Addendum No. 1

RE: Contract # C204194

Sampson-Johnston Counties

1 Section of NC 50, And 21 Sections Of Secondary Roads

Sheet No. 2

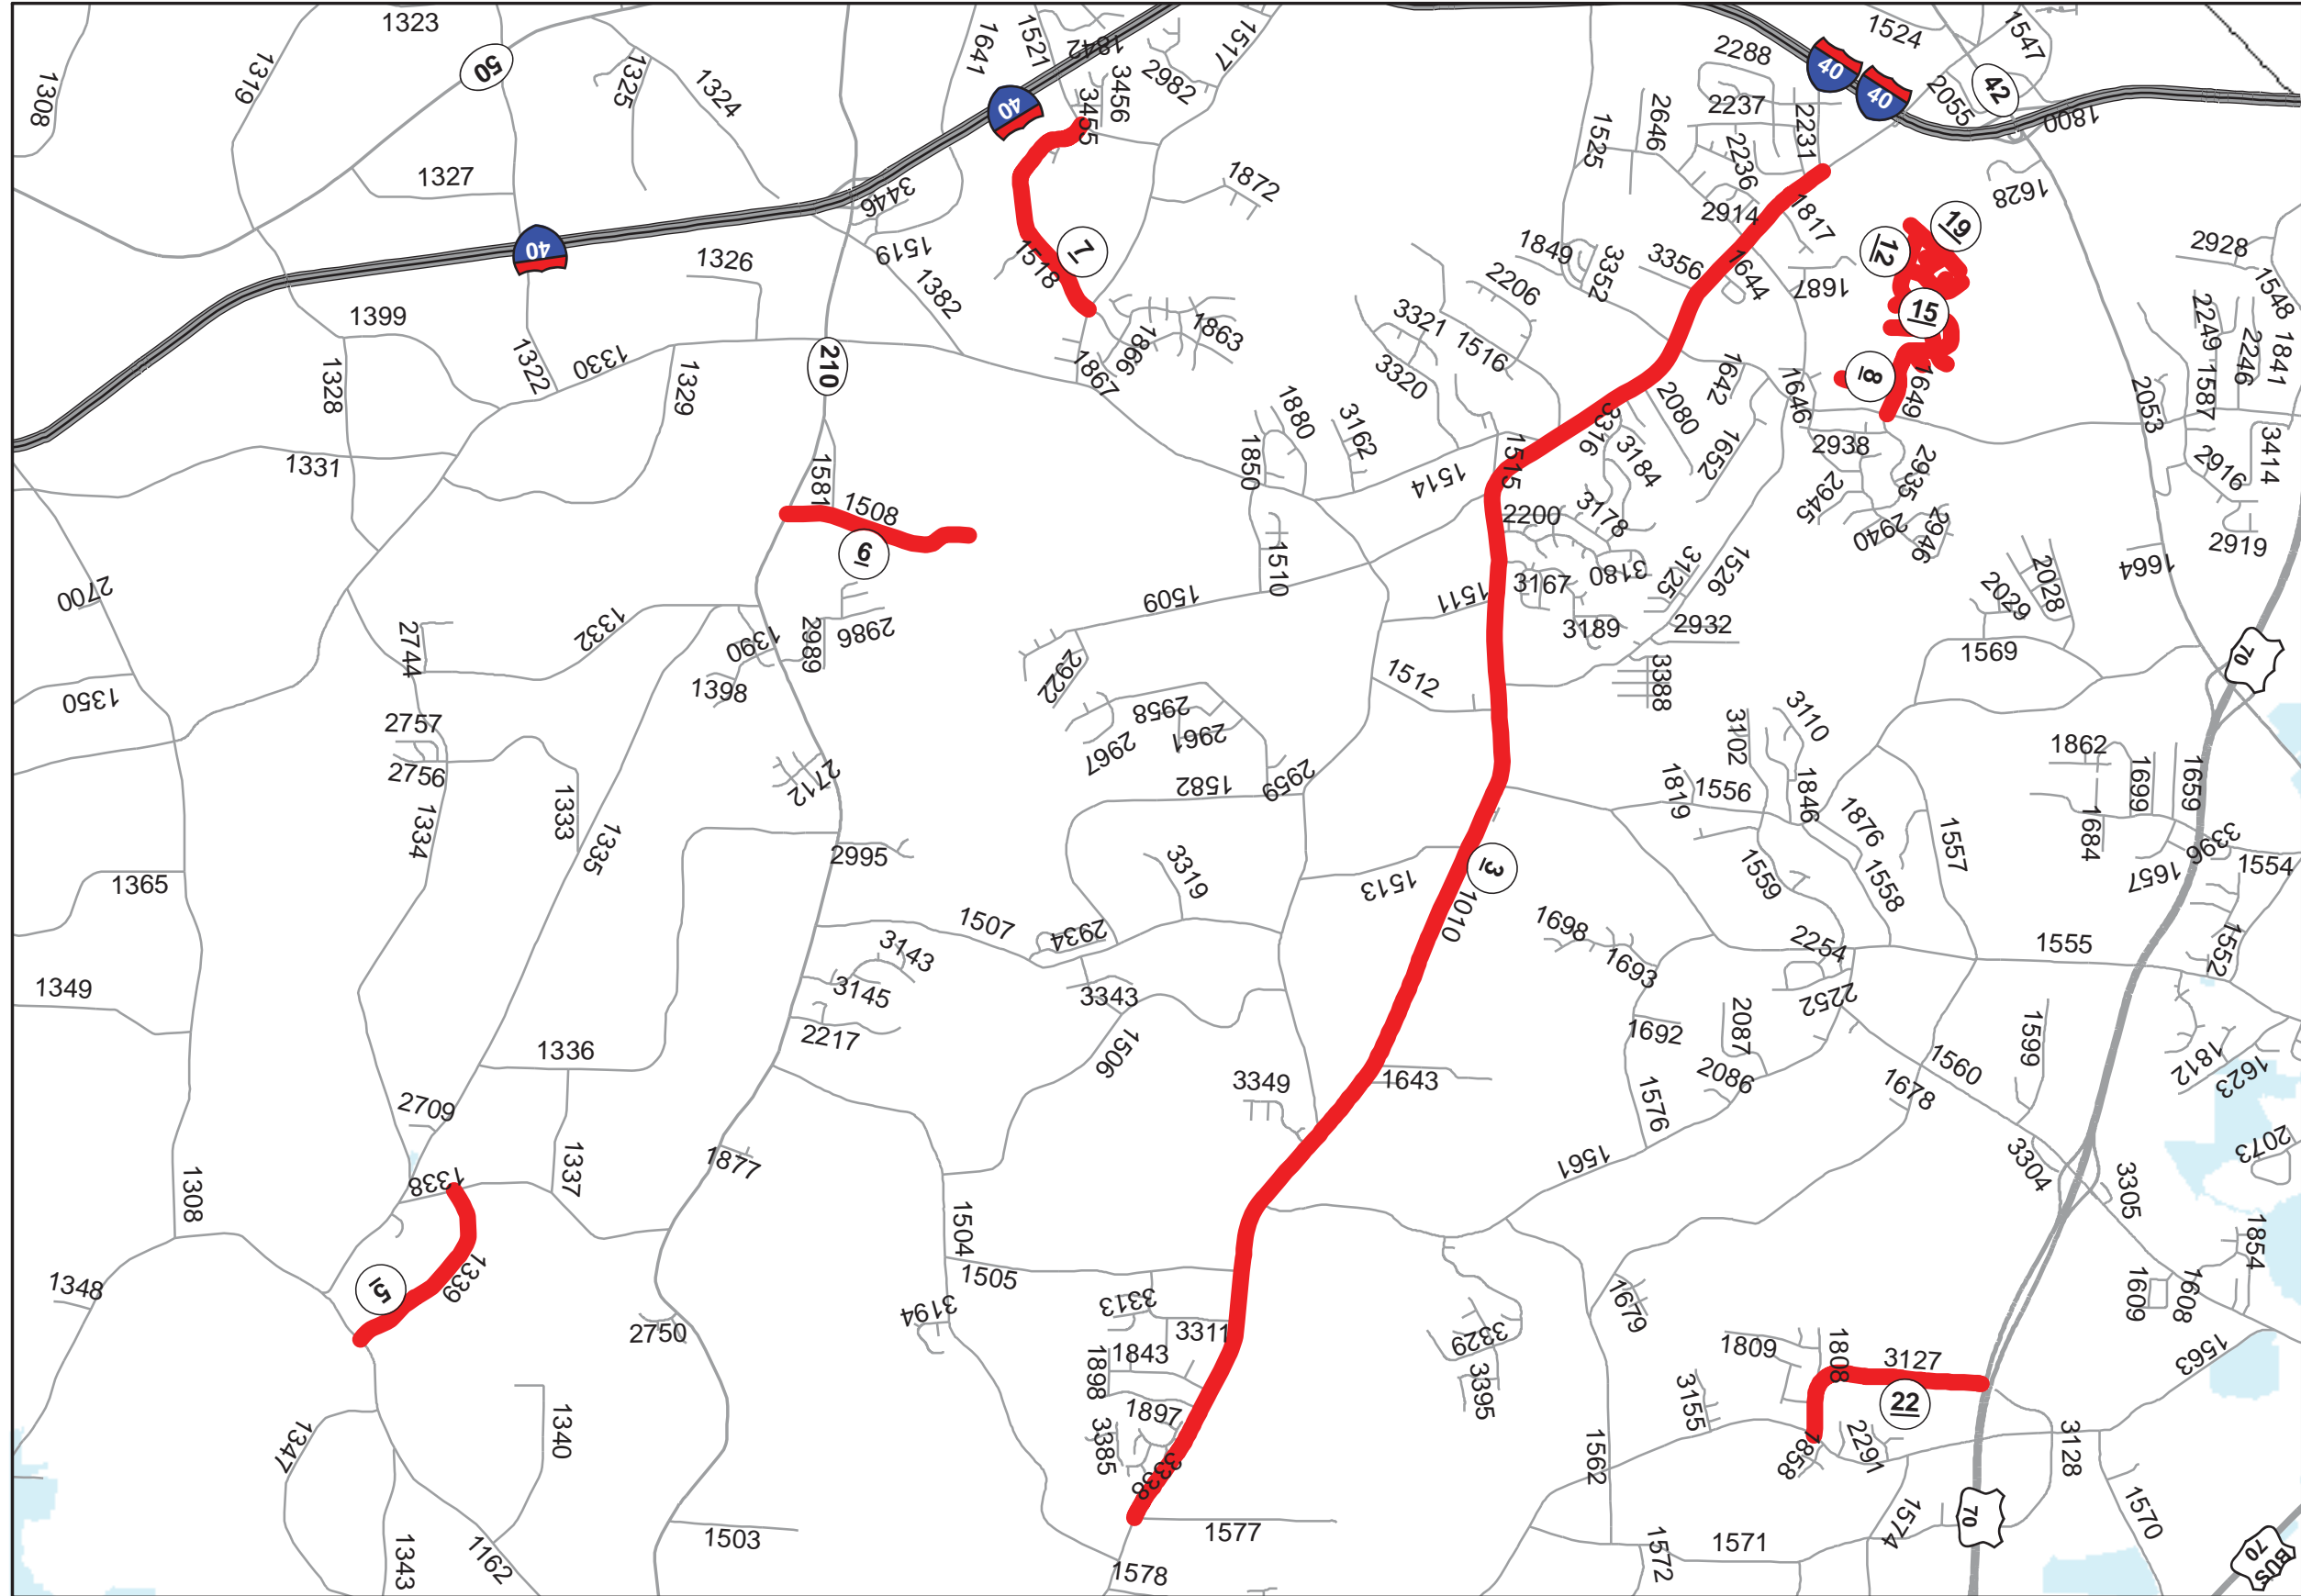
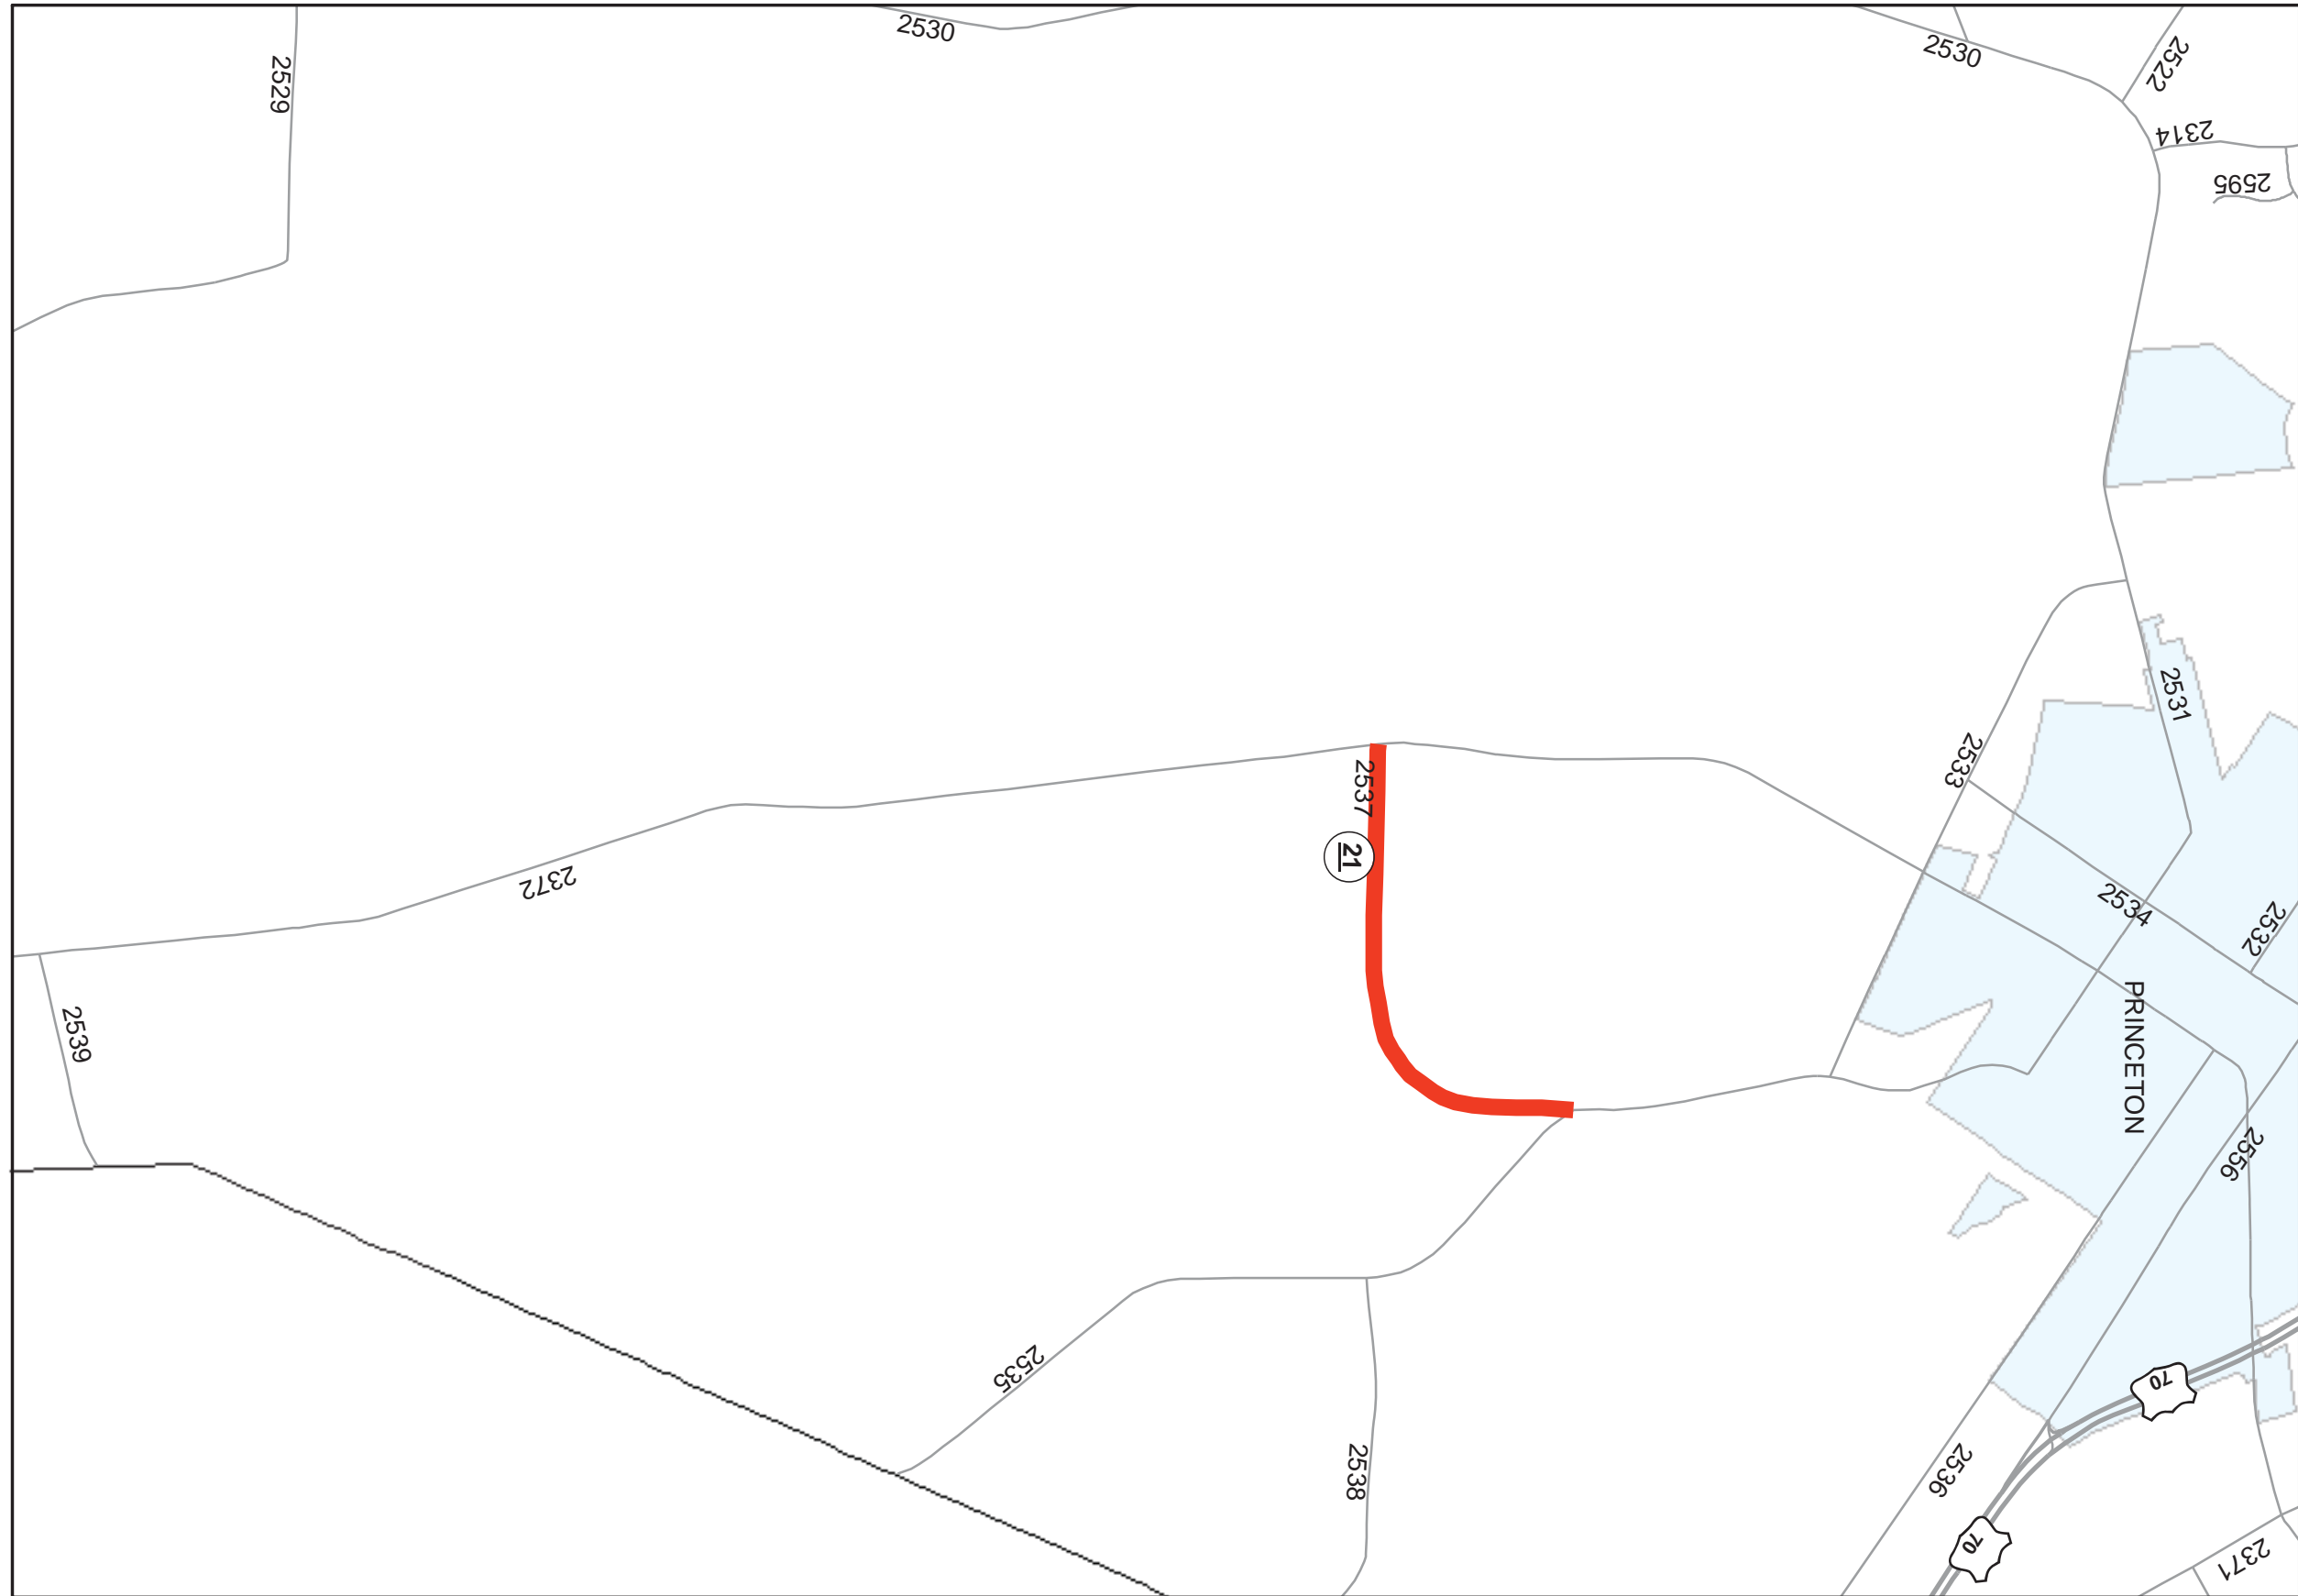
Sheet No.	Revisions
2	Revised to shorten the limits of Map #3
12 thru 13	Updated Summary of Quantities to reflect the change as noted above and as noted below on the item sheets
